KITTITAS COUNTY

DEPARTMENT OF PUBLIC WORKS

MEMORANDUM

TO: All Staff
FROM: Public Works Plan Review Team
DATE: January 24, 2024
SUBJECT: BL-24-00001 Sligmann

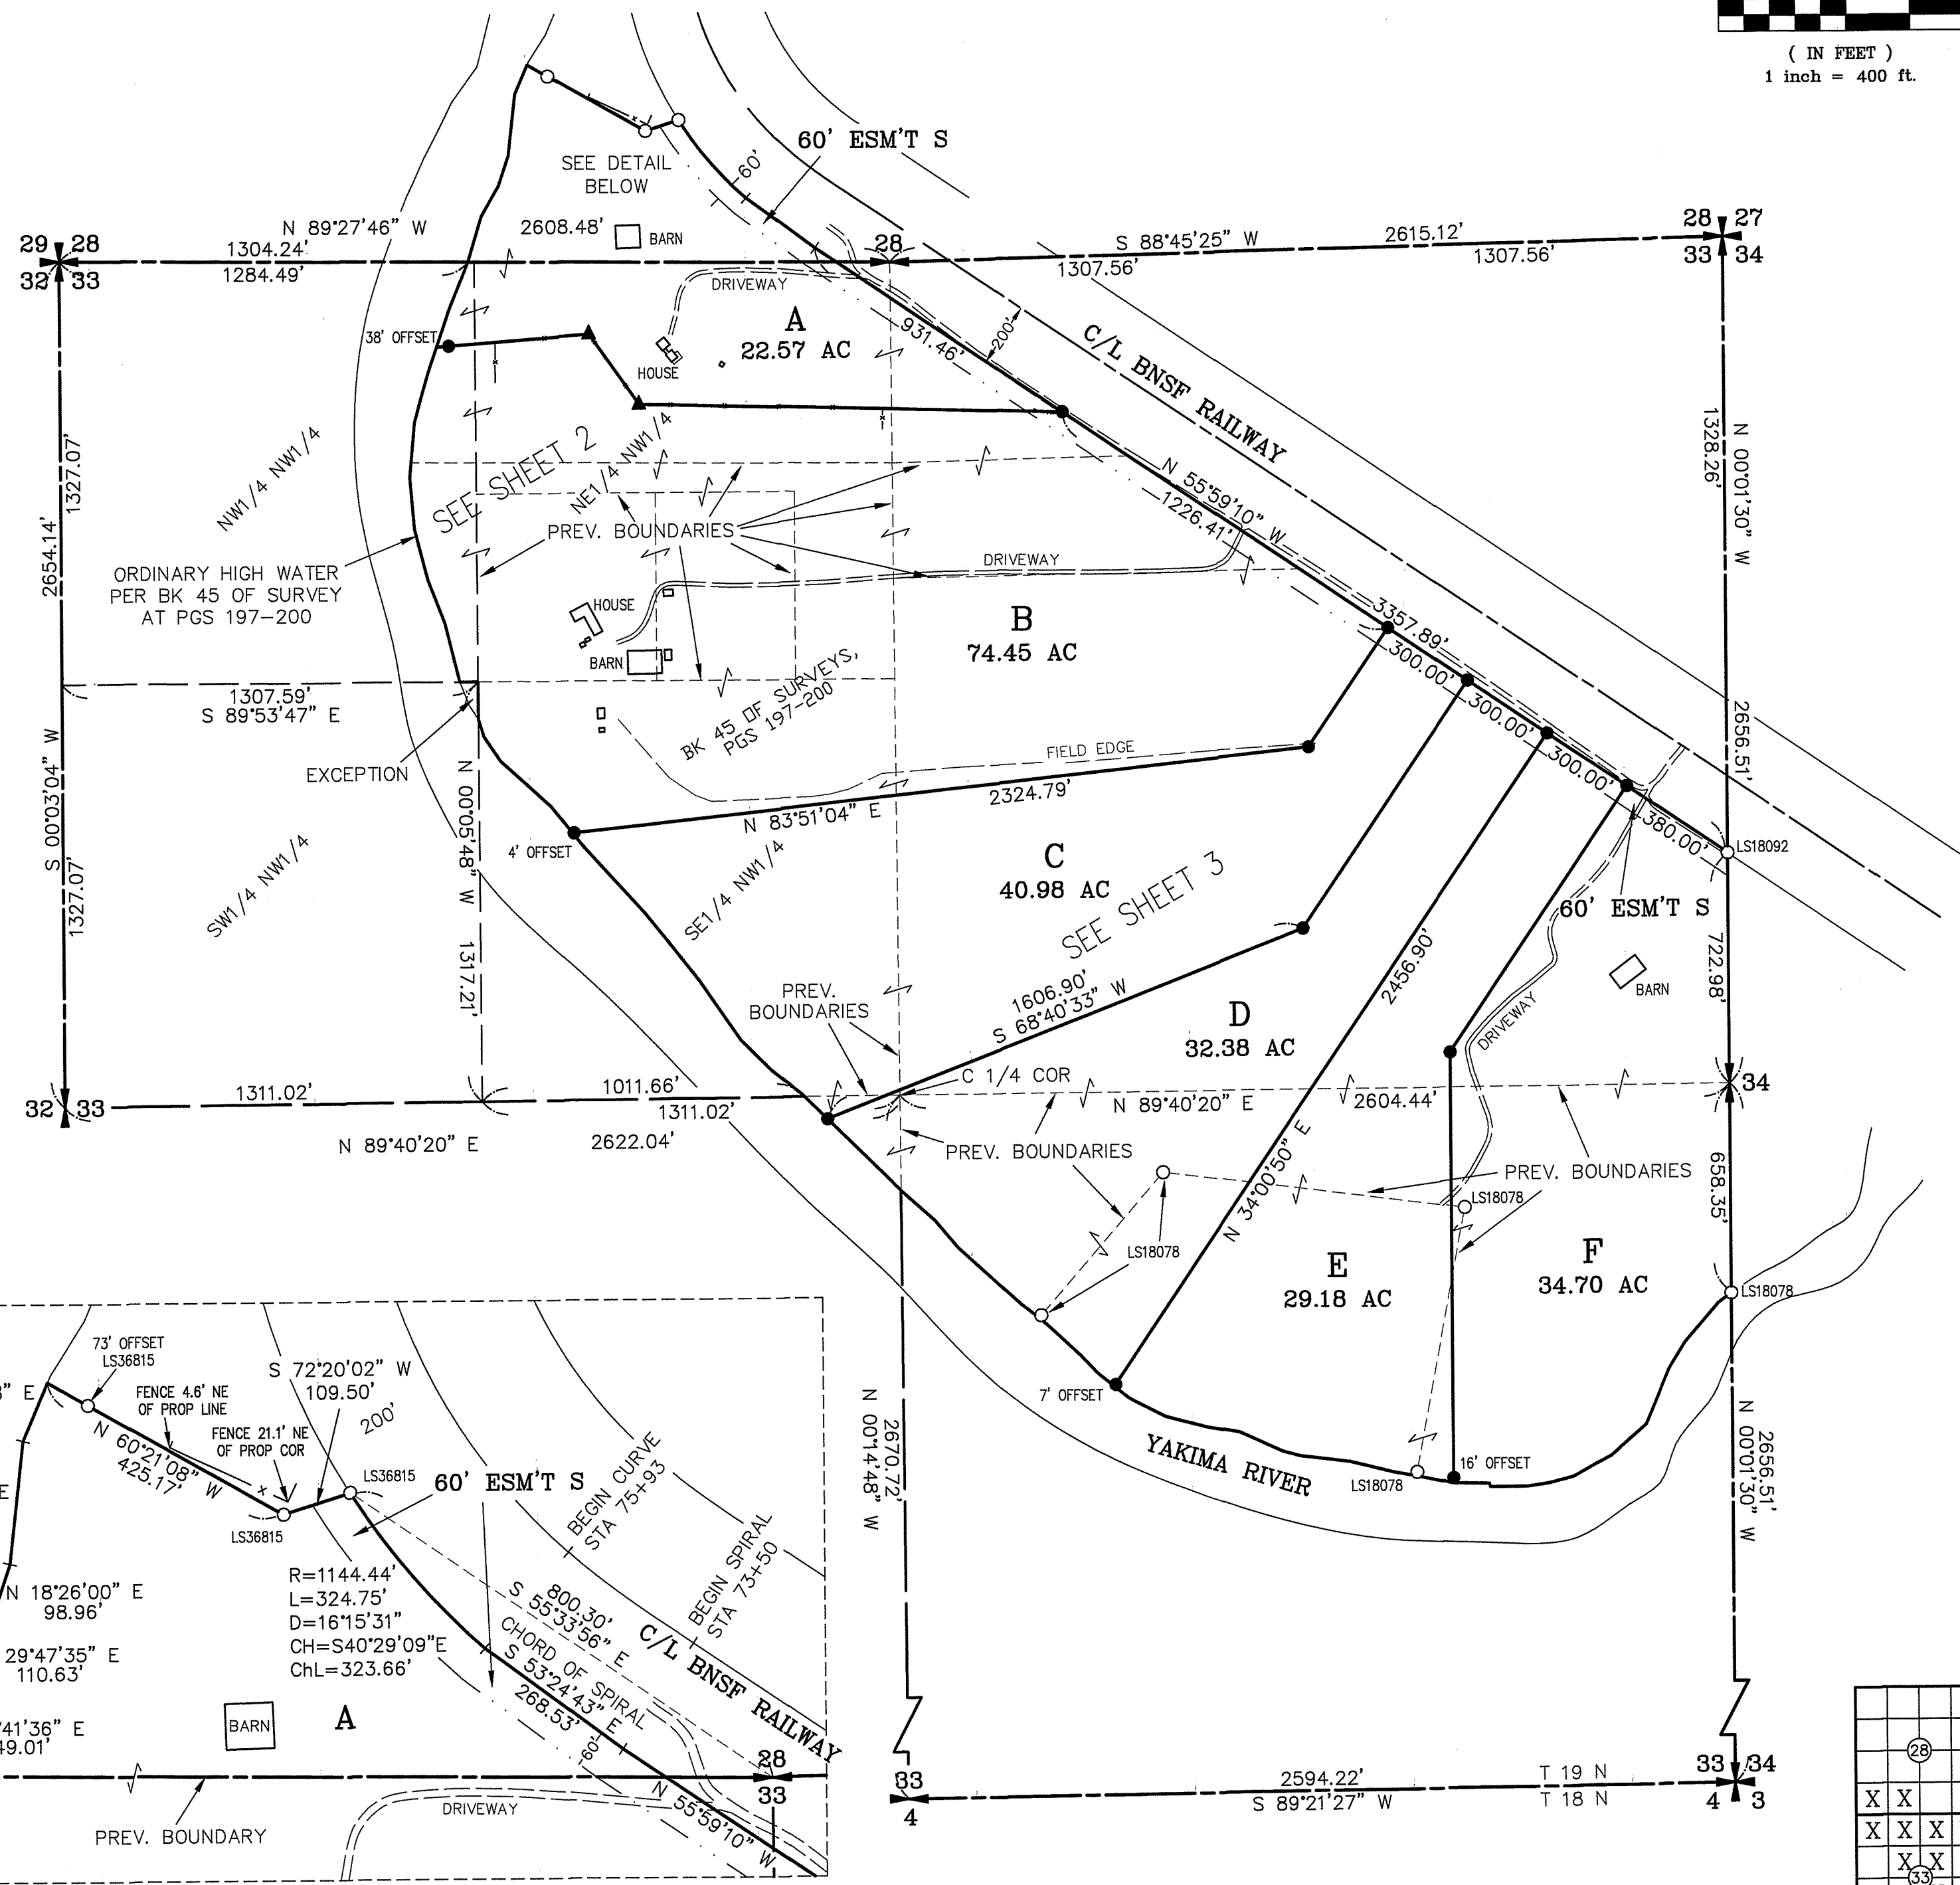
<p>ENGINEERING</p>	<p>Except as exempted in Section KCC 14.05.060, no grading or filling upon a site involving more than one hundred (100) cubic yards shall be performed without a grading permit from the County Engineer or Public Works designee (KCC 14.05.050). An application for grading in excess of five hundred (500) cubic yards shall be accompanied by an engineered grading plan (KCC 14.05.080). (CC)</p>
<p>SURVEY</p>	<p>As the application does not contain a survey map, comments herein reserved until final. (JT)</p> <p>UPDATE (02/16/2024)</p> <ol style="list-style-type: none"> 1. Minor typo in Legend (PK vs PKK)

<p>2. Show legal access to Dudley Road. This is for visual reference only and does not need to be dimensioned. Please include AFN's for any easements or crossing agreements.</p> <p>3. Please include some reference on the face of sheet 1 that Easement S is proposed or to be created via separate document.</p> <p>4. On sheet 3, the Westernmost boundary line bearing of Parcel F is obscured by crossing linework.</p> <p>5. The section corners shown as "Calc" cannot be recreated from the provided references, as no portion of the referenced documents tie to the found corners as shown. Please include suitable notes or document reference so that the methods to calculate these corners can be recreated by others. (While the angle and distance along the north line of the section to calculate the NW corner appear to be from Survey: 17-167, it is uncertain what was utilized to calculate the SE corner position.)</p> <p>OF NOTE (changes not required) Proposal appears to include parcel APN:077834 per county GIS. County Assessor is working on resolving this.</p>
